July 11, 2023

G-5713

Subject: Geotechnical Review of Proposed Tree Watering
Proposed New Residence
3064 – 68th Avenue SE
Mercer Island, Washington

LANDSCAPE PLAN

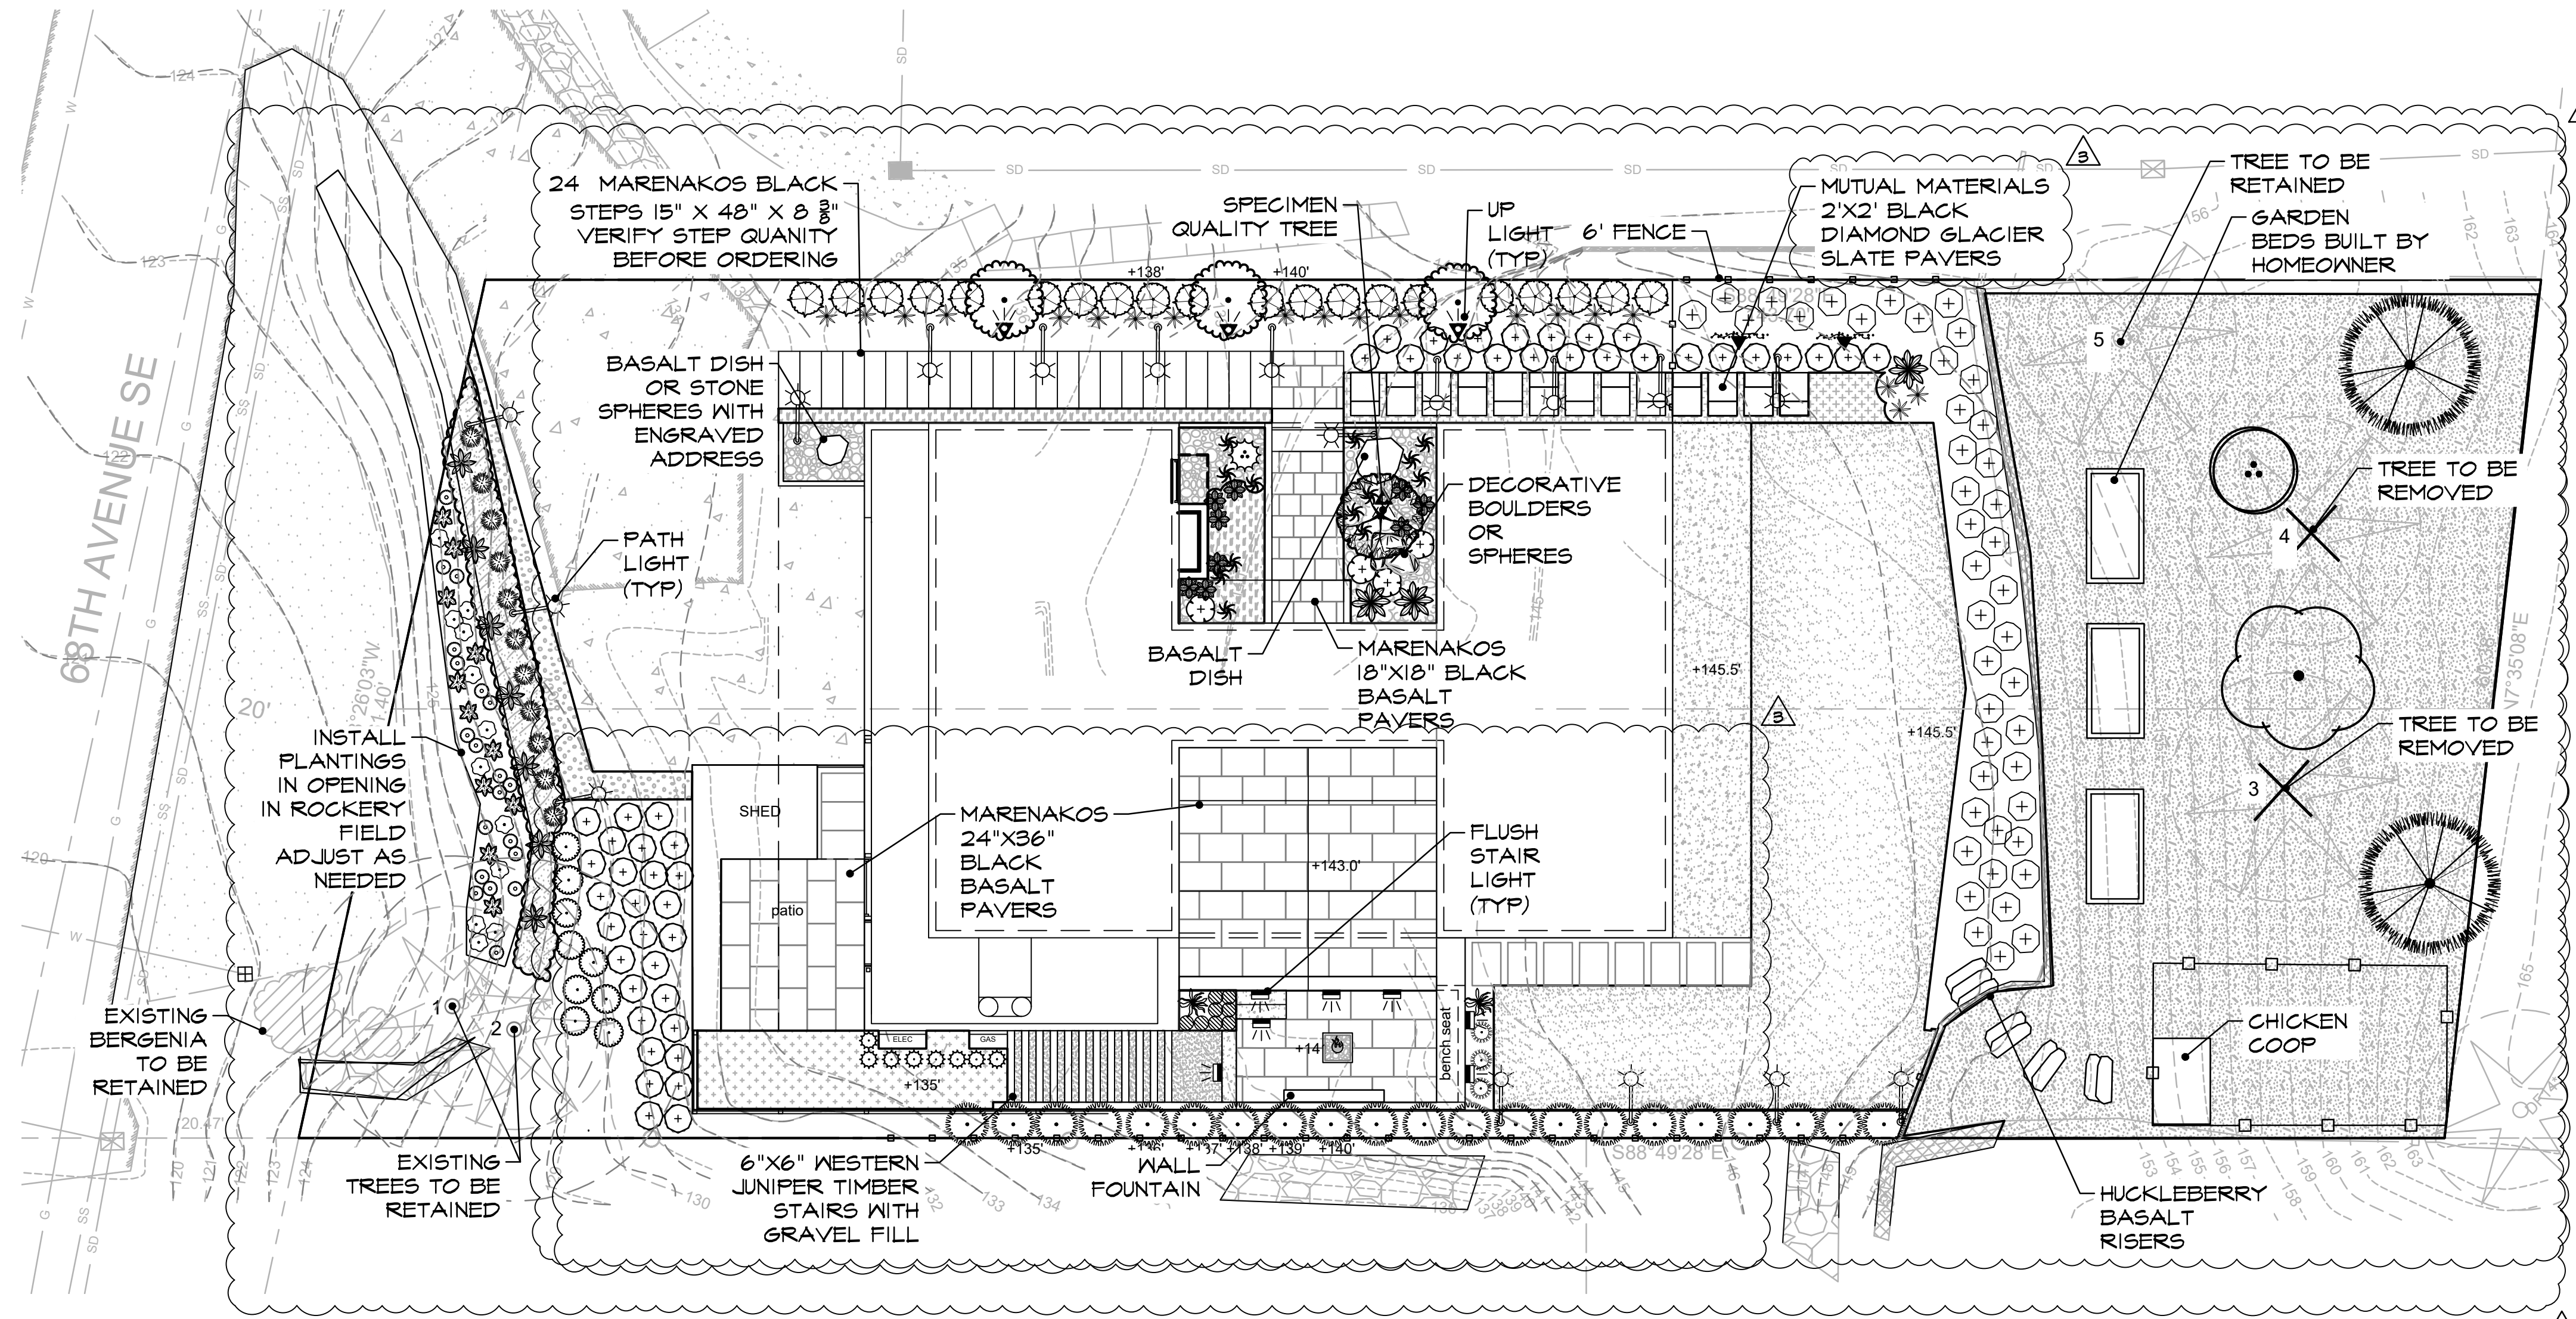
Per the request of Ms. Kayla Jorgensen of Root of Design LLC, GEO Group Northwest, Inc. has reviewed the proposal to use a temporary irrigation system with drip bubblers for a minimum of 5 years for six new (replacement) trees at the subject property. These trees will be located on a slope area that is beyond and uphill from the eastern limits of development associated with the construction of a new residence on the property.

Upon our review of the geologic and topographic conditions and of the details of the proposed development activity, it is our opinion the proposed watering system is acceptable from a geotechnical perspective and has minimal risk of adversely affecting stability of the site property or adjacent property.
